Consultation Response from KC, Highways Development Management
2024/91571 DC Ground And Tree Care, Station Lane, Heckmondwike, WF16 0NF
Erection of new warehouse/office unit
Date Responded: 11/12/2024. Responding Officer: D. Stainsby Responding Ref: K9-10SE/11

Figure 9 Proposed Site Layout

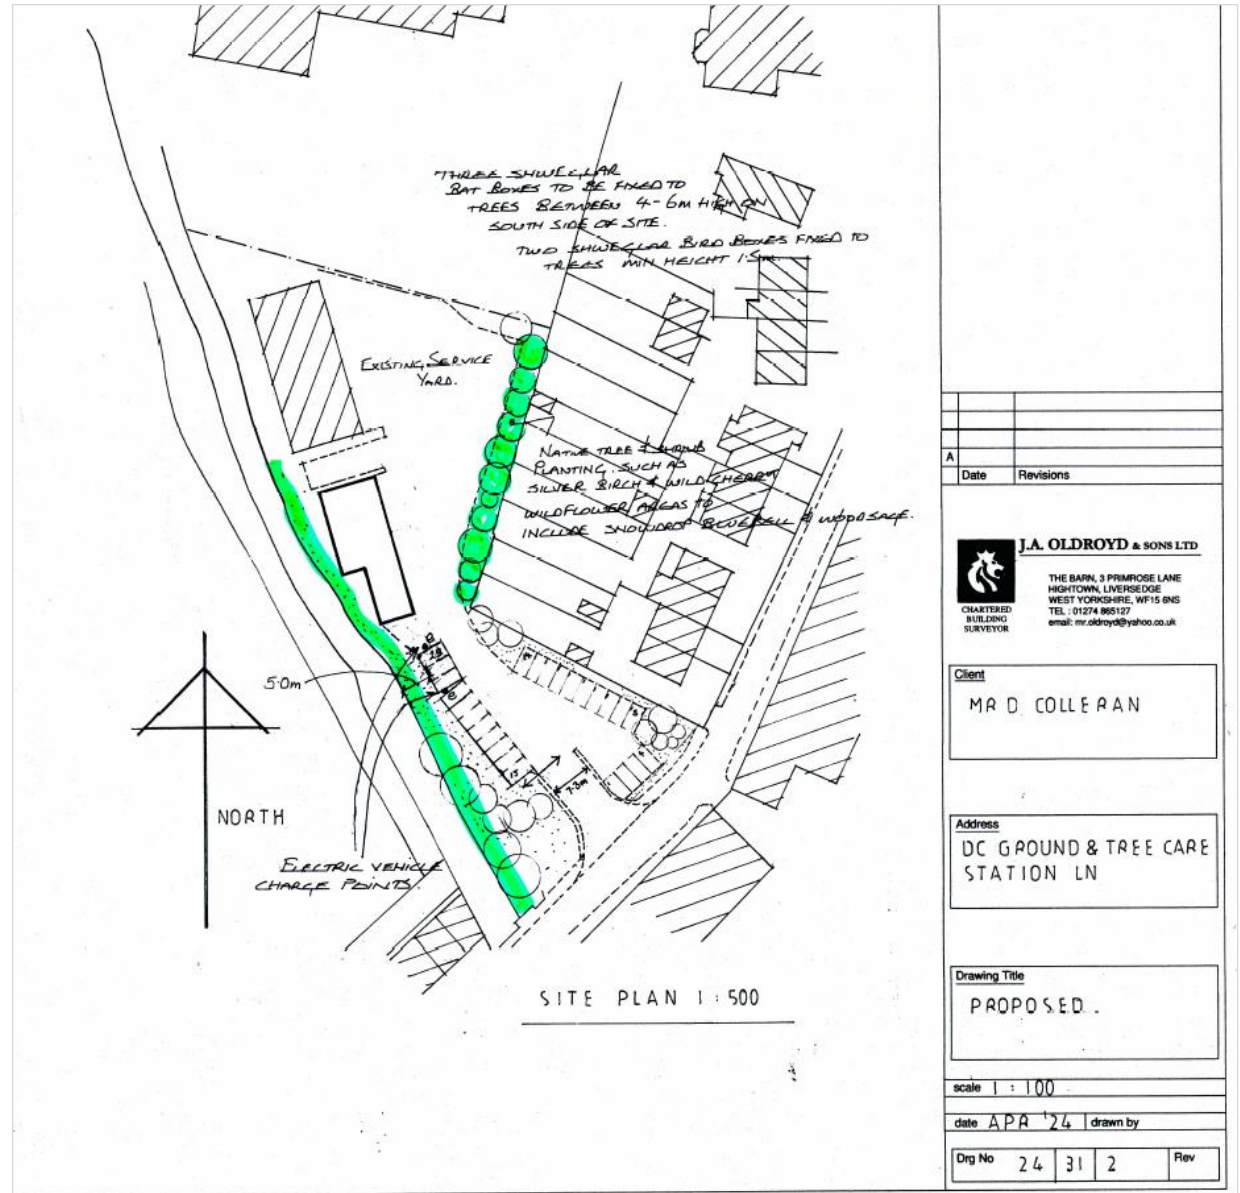
The proposed car parking shows there is provision for 25 vehicles, including 3 EV charging points. However, no disabled parking spaces has been provided.

A revised plan showing the provision of a disabled car parking space should be provided.
